March 1, 2006

Joseph Frustaci
8 Rosewood Lane
Cape Elizabeth, ME 04107

The City has been keeping itself apprised of your development at Farragut Street in Portland, Maine. The performance guarantee you posted in October 2003, from Gorham Savings Bank, will come due on April 16, 2006. The City will initiate the calling of this guarantee unless the following punchlist of items is addressed:

15 CASCO TRAP DETAIL
NOT TO SCALE

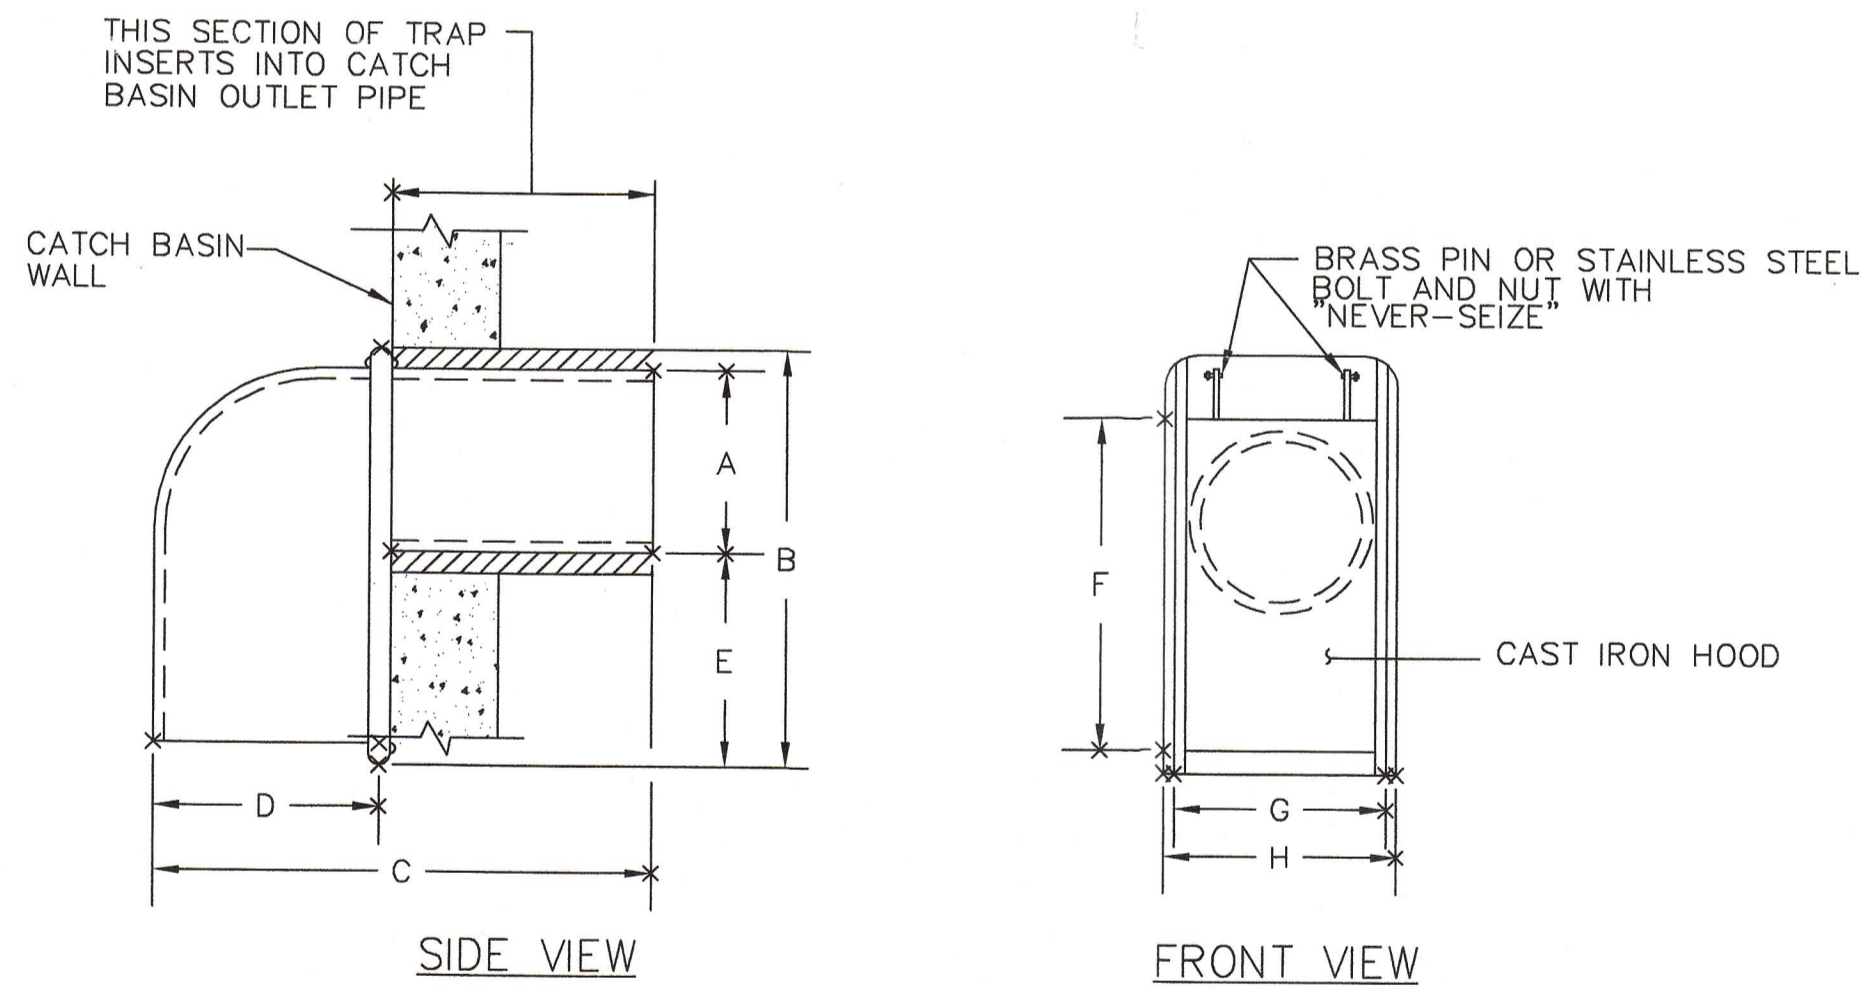
1. As built drawings in CAD and mylar form must be submitted to the City.
2. Surface pavement on the road needs to be laid.
3. Driveway aprons must be paved.
4. Repair of a manhole cover damaged by plowing must be completed.
5. Two catchbasins and the installation of casco traps in the same must be completed.
6. Grass in the gutter line must be killed or removed prior to paving.
7. Stabilization of all lots not yet built on must be accomplished.
8. Lein waivers from all subs and suppliers must submitted to the City.
